Subject: Y/71/20/RES

Engineers Comments Regarding Surface Water Drainage

Reserved Matters Comments

ROAD TYPE 5 & 5A CONSTRUCTION DRIVEWAY
PERMEABLE BLOCK PAVING

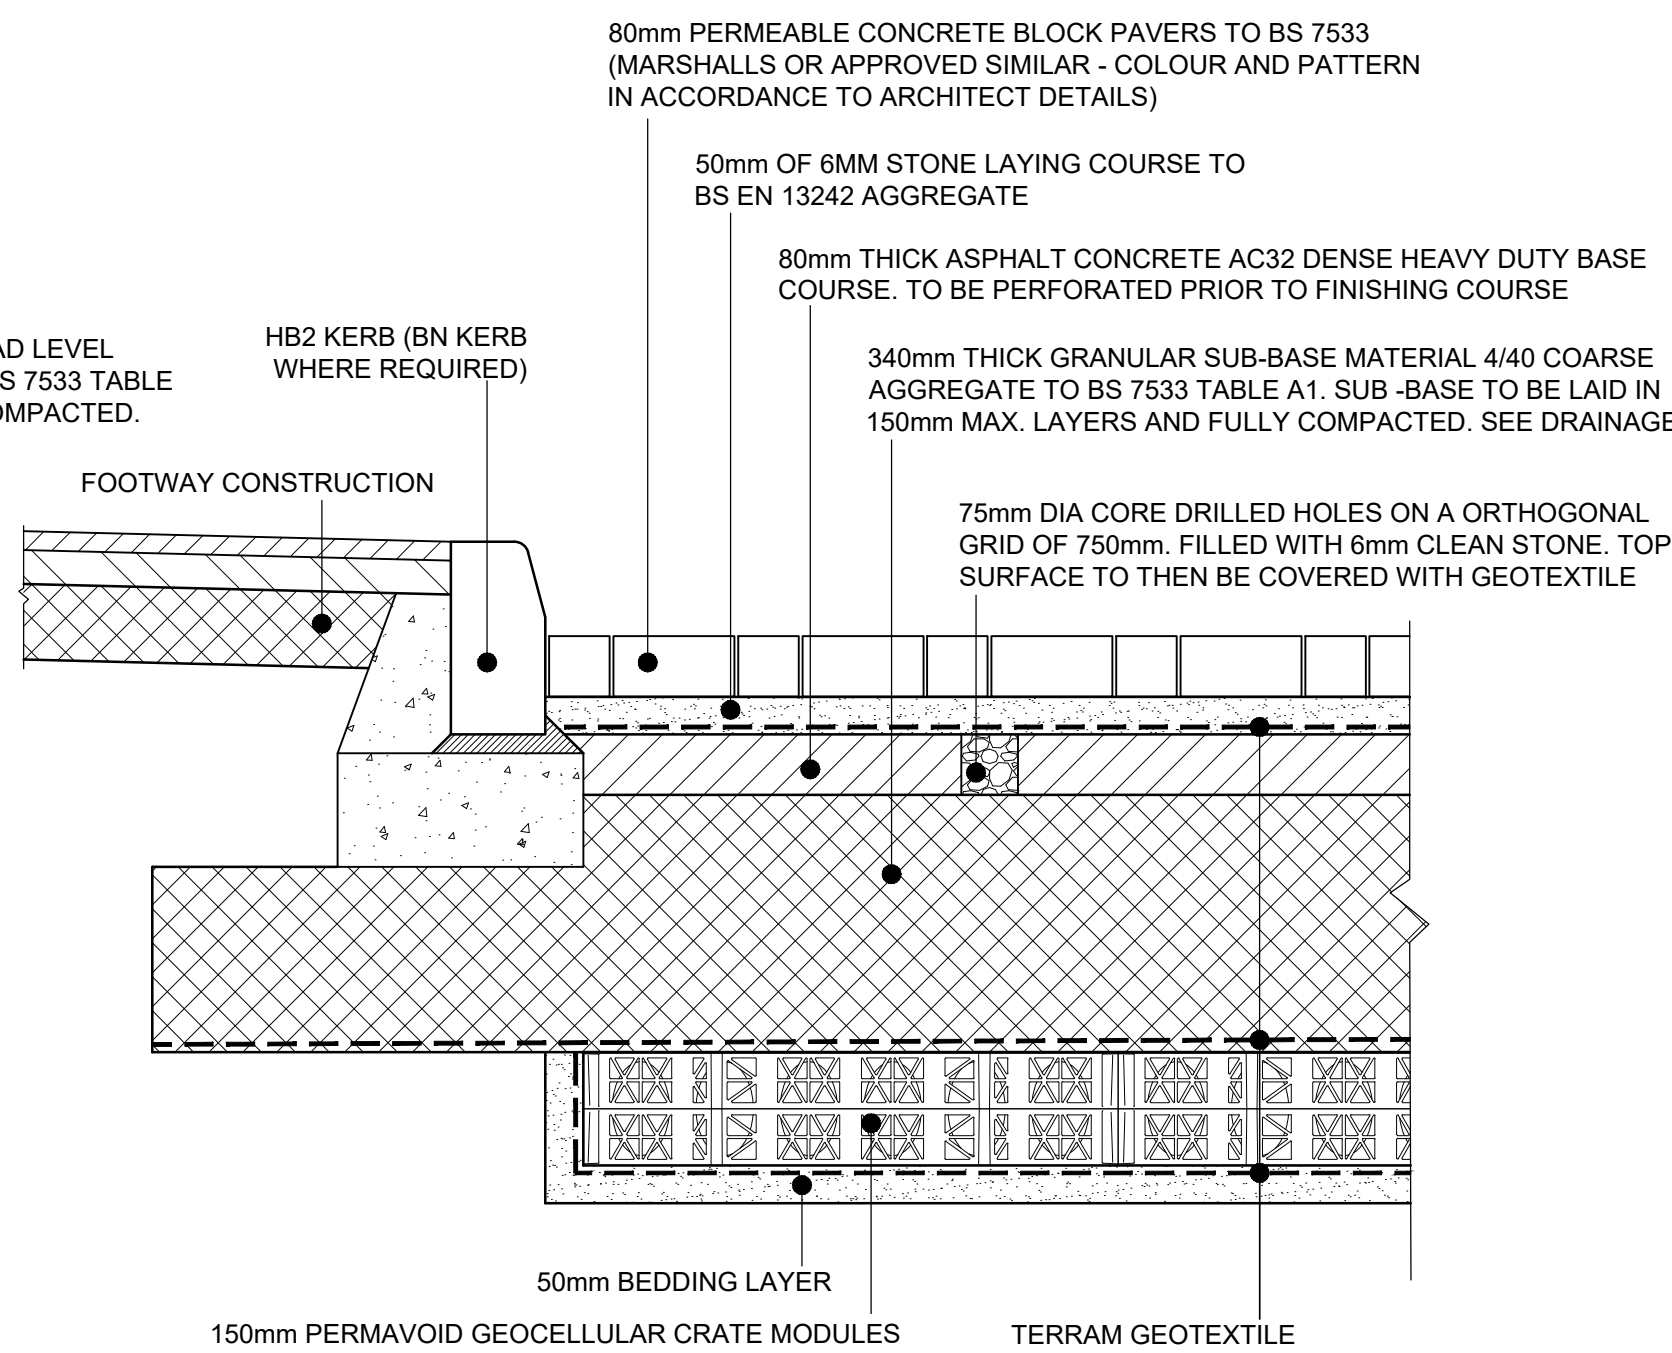
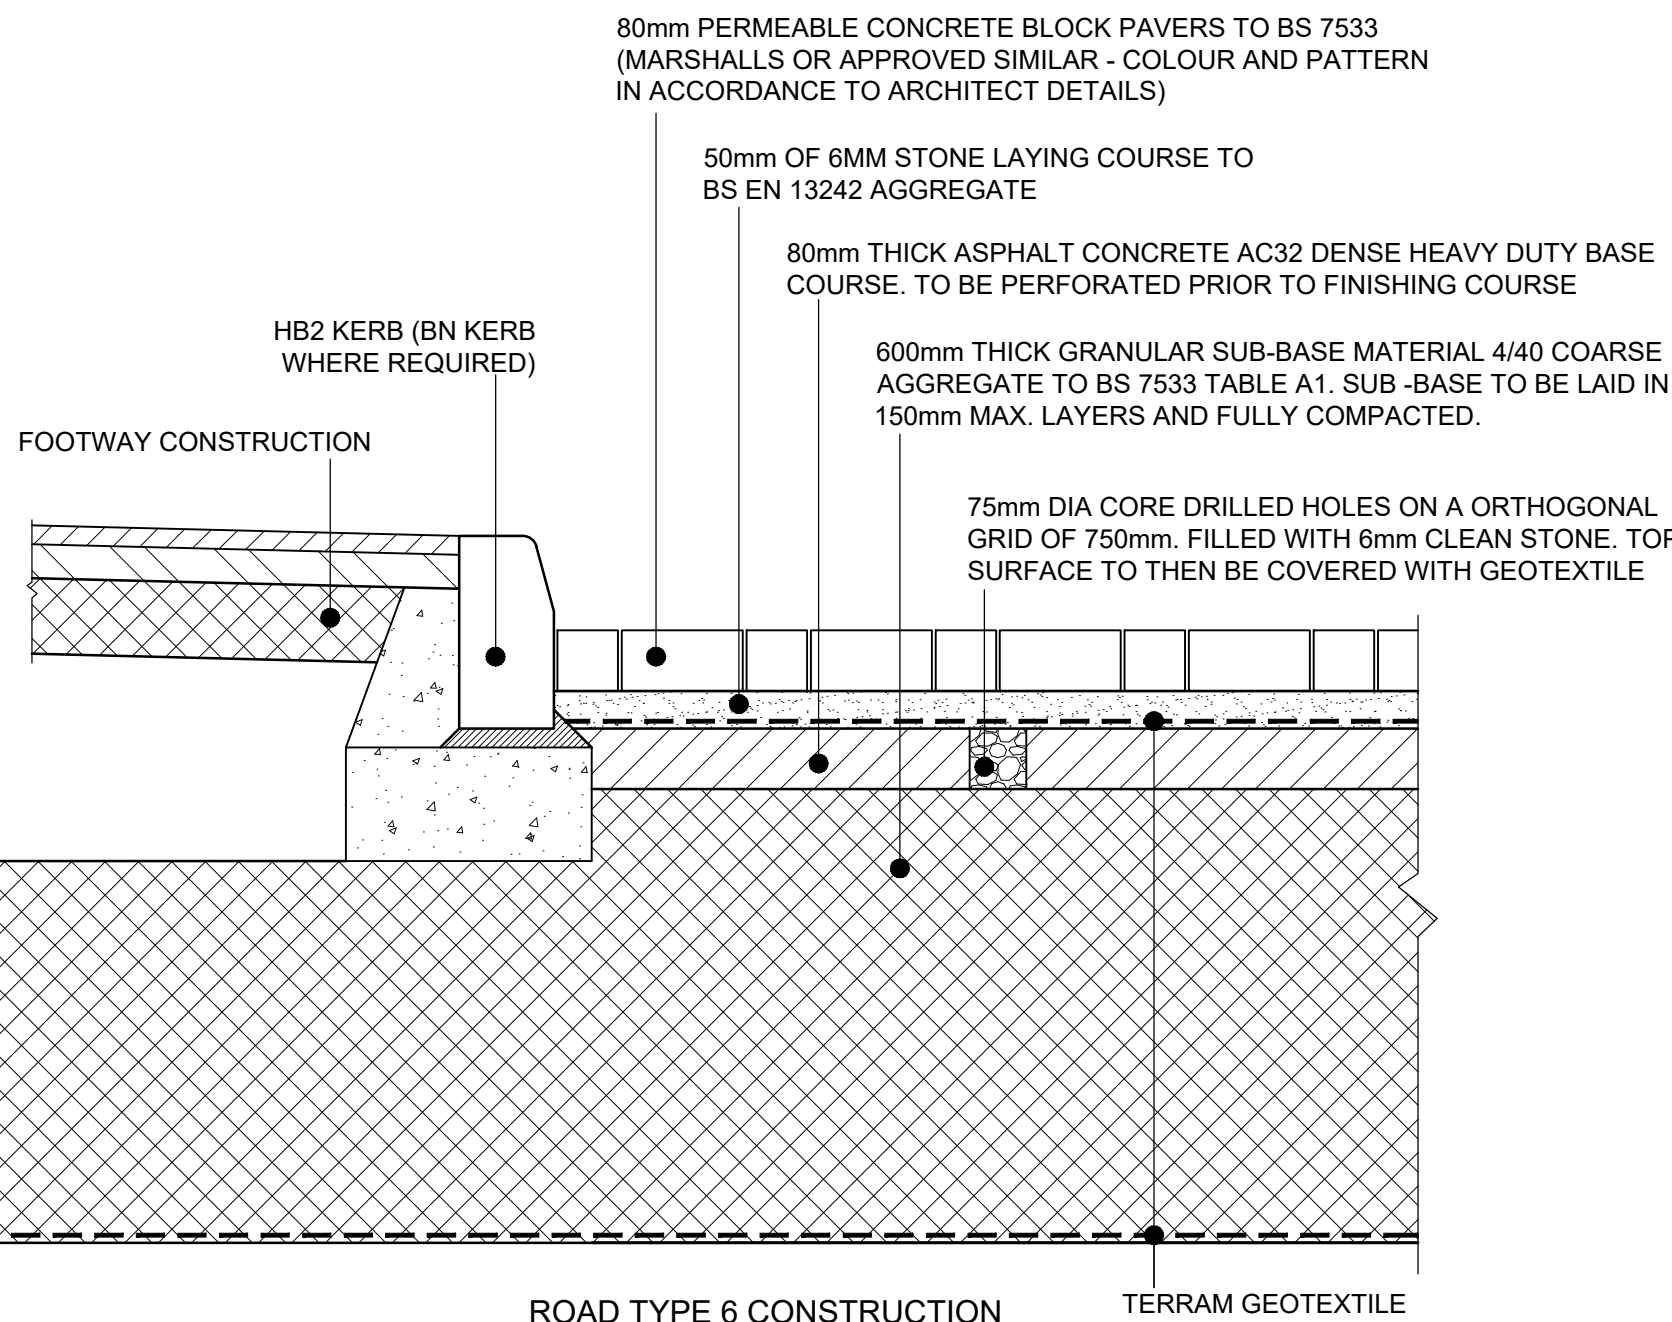
3. Within the checklist it is stated that all infiltration devices are kept to a maximum of 600mm depth. Yet permeable paving area 1 has a total depth of 770mm, permeable paving area 2 has a total depth of 710mm,

permeable paving area 3 has a total depth of 780mm, permeable paving area 4 has a total depth of 860mm. Please review or provide evidence that all features are located above peak recorded groundwater level, i.e. put groundwater levels on the drainage plan.

4. It is understood that the permeable paving areas will not have a flat sub-base, please provide spot levels on the drainage layout showing finish and formation levels of permeable paving.
5. Construction detail drawings of check dams have been provided, please clearly indicate on plan where these are proposed.
6. Please provide impermeable areas plans that clearly show the areas draining to each surface water drainage feature. Preferably provide these in dwg to facilitate paperless review.
7. Please provide network calculations.
8. A full review of calculations will be completed once this information is supplied.
